From: Wes Smart [REDACTED]
 Sent: 26 January 2011 16:28
 To: Planning.Responses
 Cc: [REDACTED]
 Subject: Objection to LU/5/11 - Addition of Café facilities

PLANNING APPLICATION NO LU/5/11 REVISION TO LU/173/10

Proposed conversion of seafront shelter to Café with surfing facilities, The Promenade, Sea Road, by Mr Coupling

SEATING SHELTER.
The Promenade.
SEA ROAD.
LITTLEHAMPTON.
BN16 2LX.

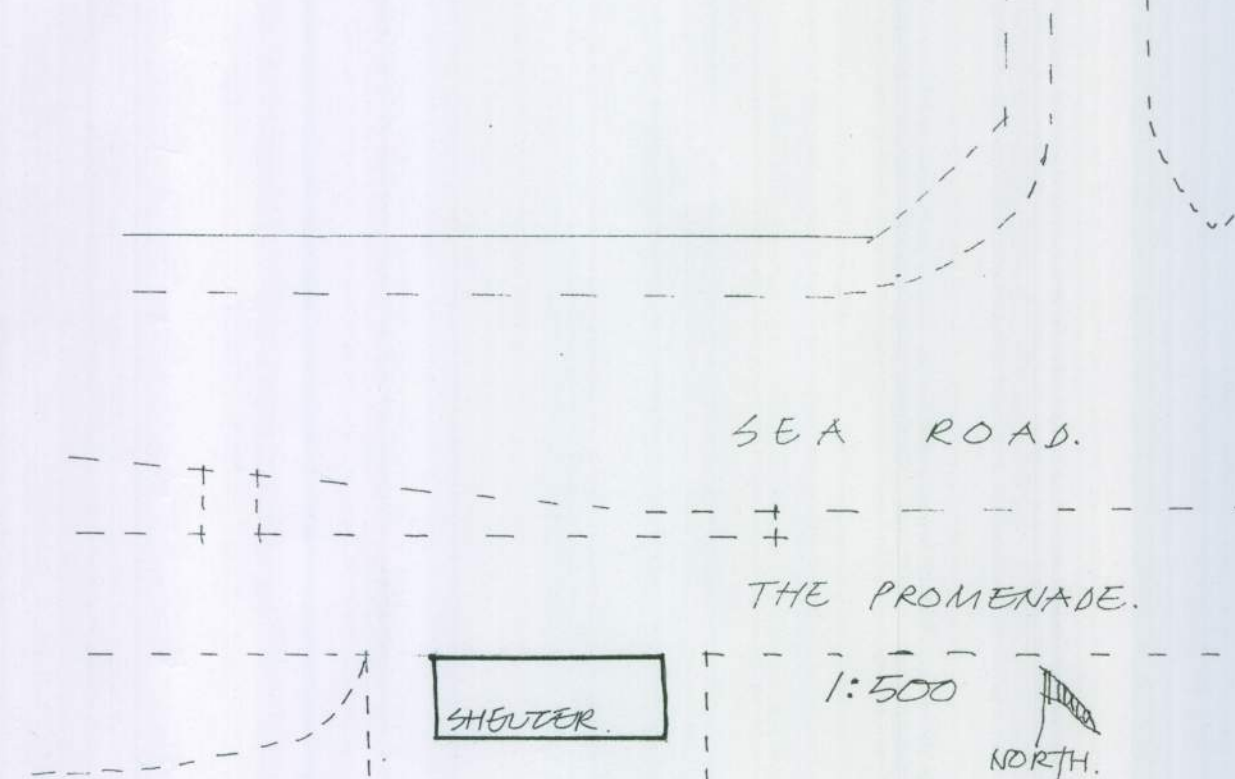
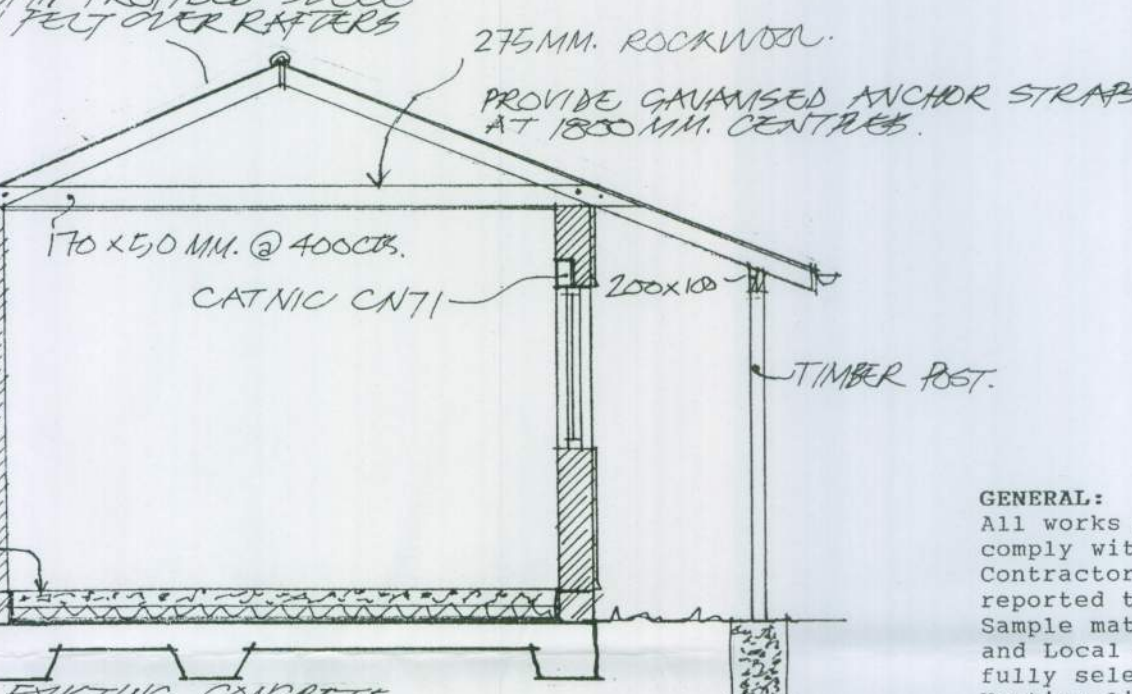
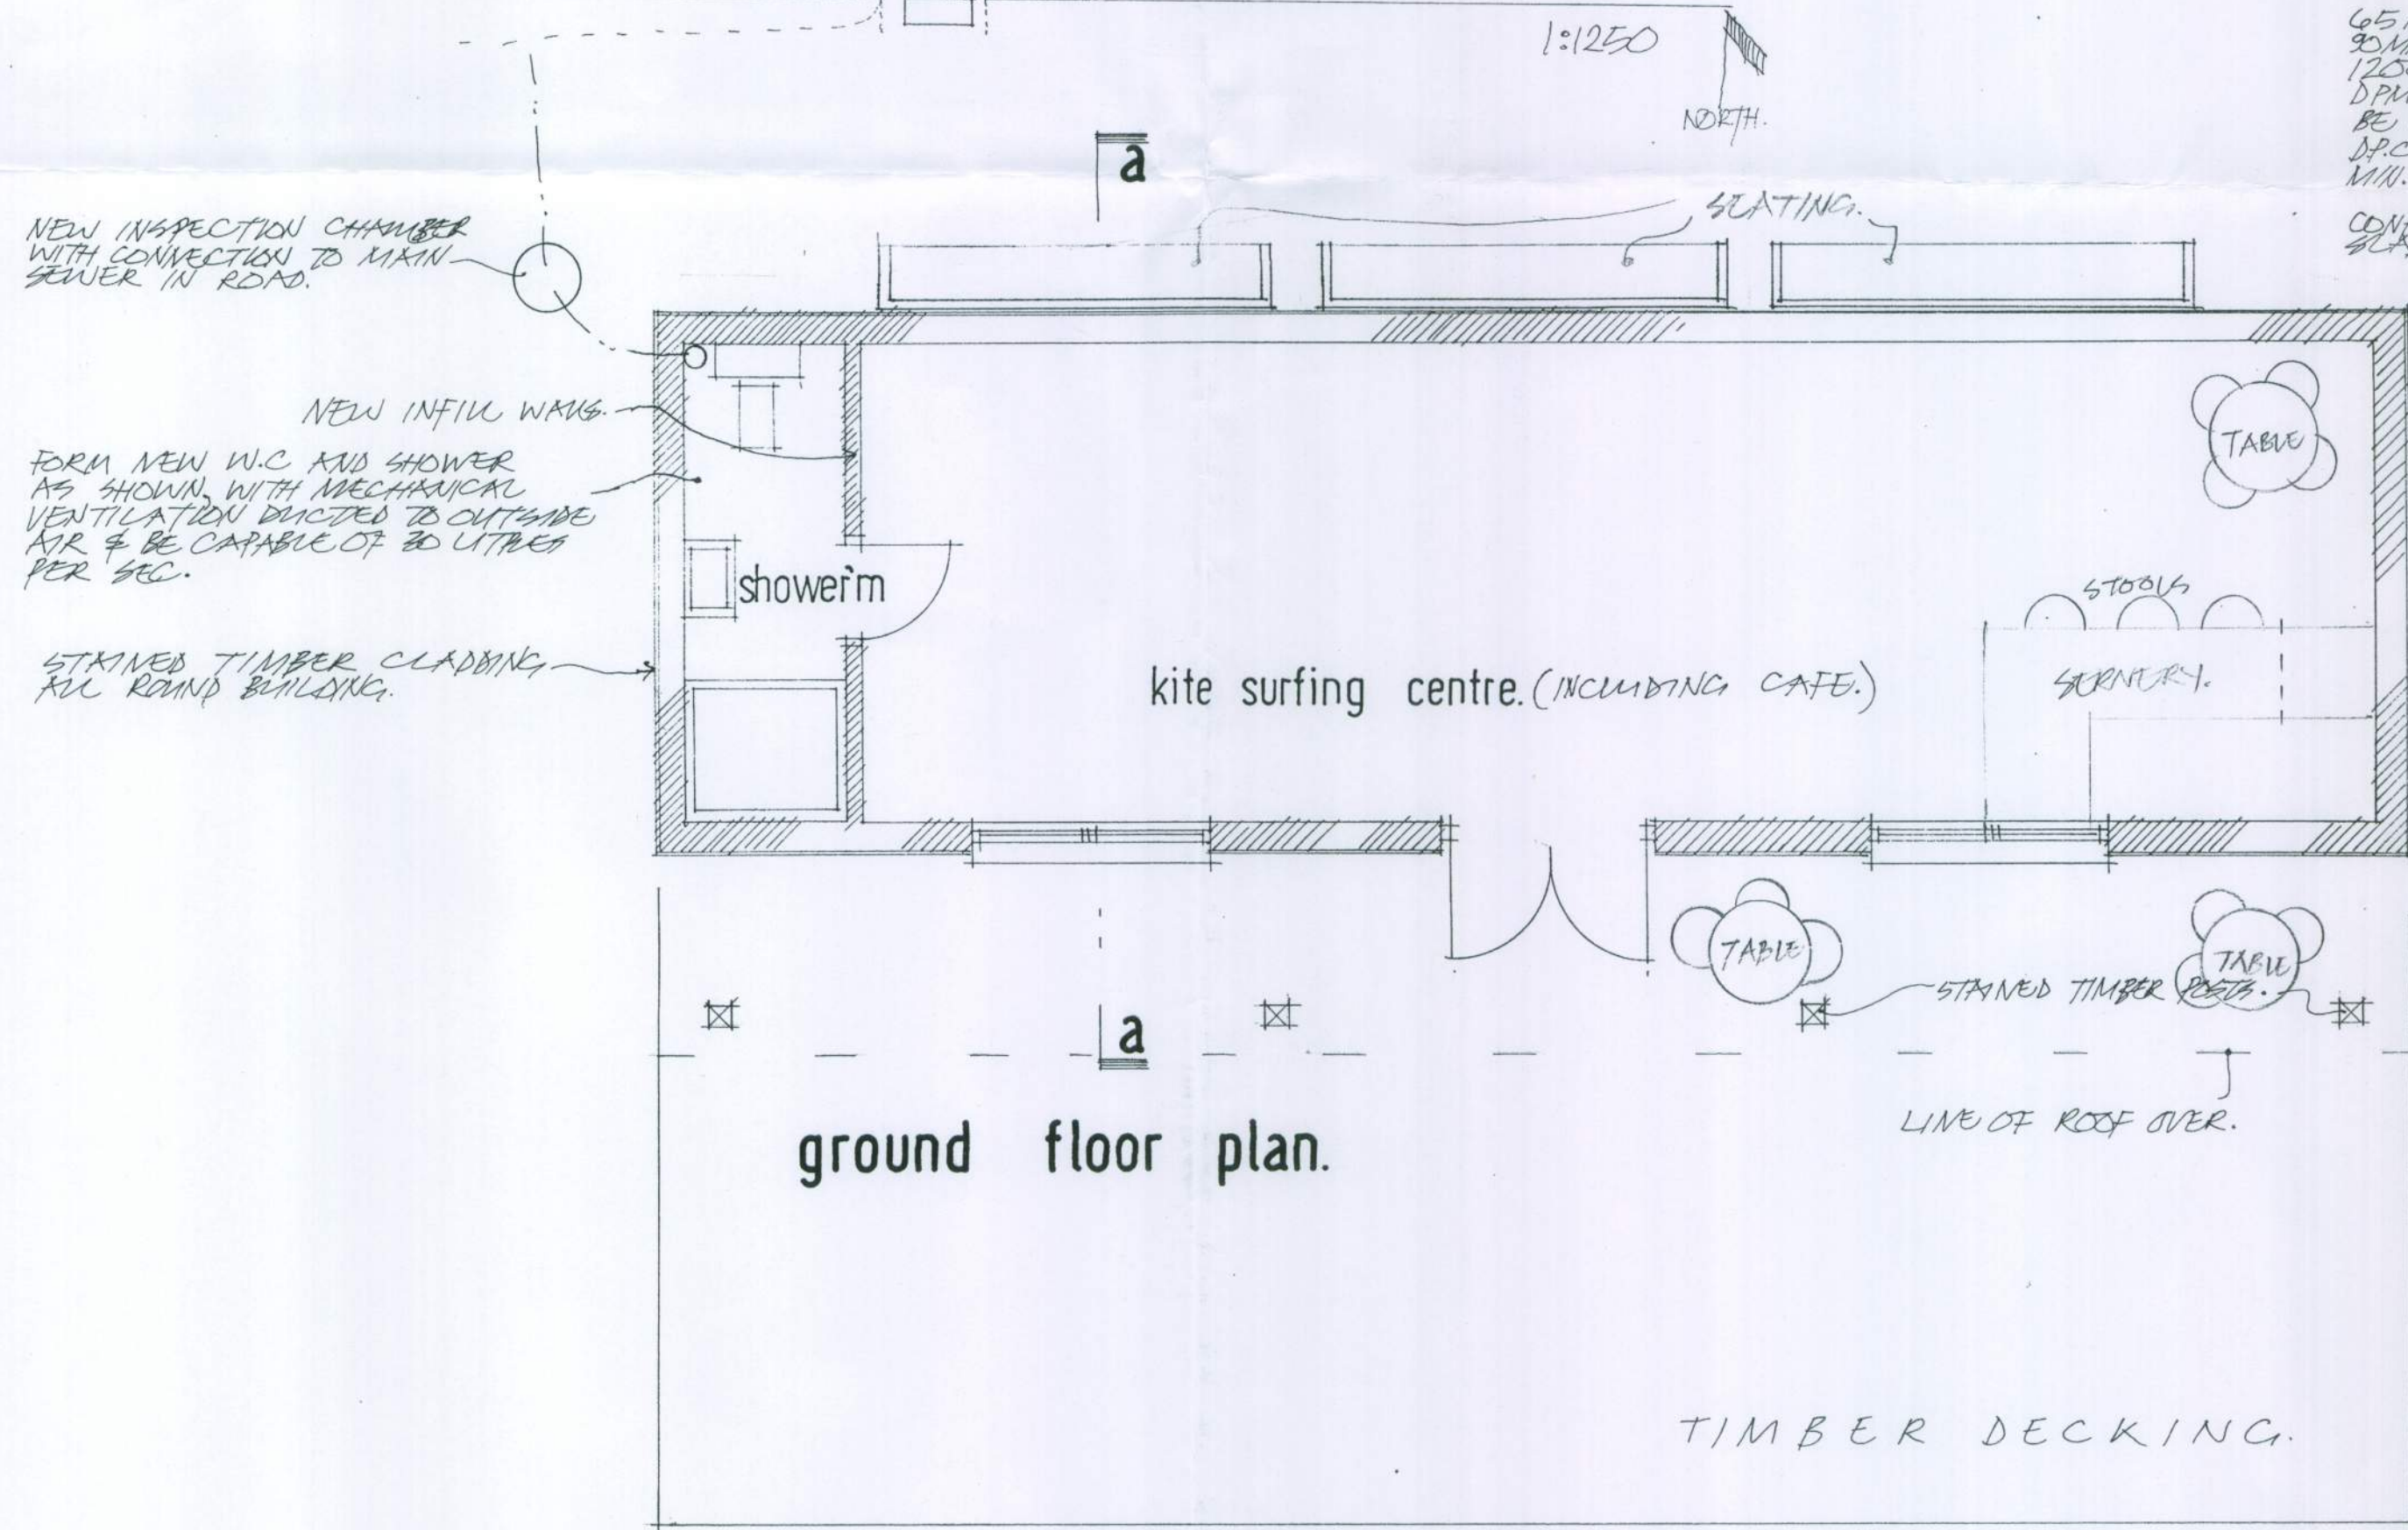
Whilst I was highly disappointed to see the loss of the only permanent shelter between Rustington and Littlehampton, some accommodation had been made for shelter however slight they are on the north elevation of the proposed building. "Café facilities, no detail of which is contained upon the plans, will require extractor fan flues, waste storage, recycling storage and deliveries. With prevailing winds the only place for all these functions to take place will be on the northern elevation. A key aspect of compromise, the need for seating and cover for pedestrians, has been at best eroded at worst lost.

I would question the adequacy of the kitchen area in the layout of the centre as provision for seating inside and outside, if open to the general public could be servicing a large amount of people. This coupled with club members and students on a daily basis questions the suitability of the site for this additional facility. ☐

Students/clubmembers will be changing in close proximity to the cafe/kitchen and the plans do not give enough detail to see how these areas are to be kept separate. ☐
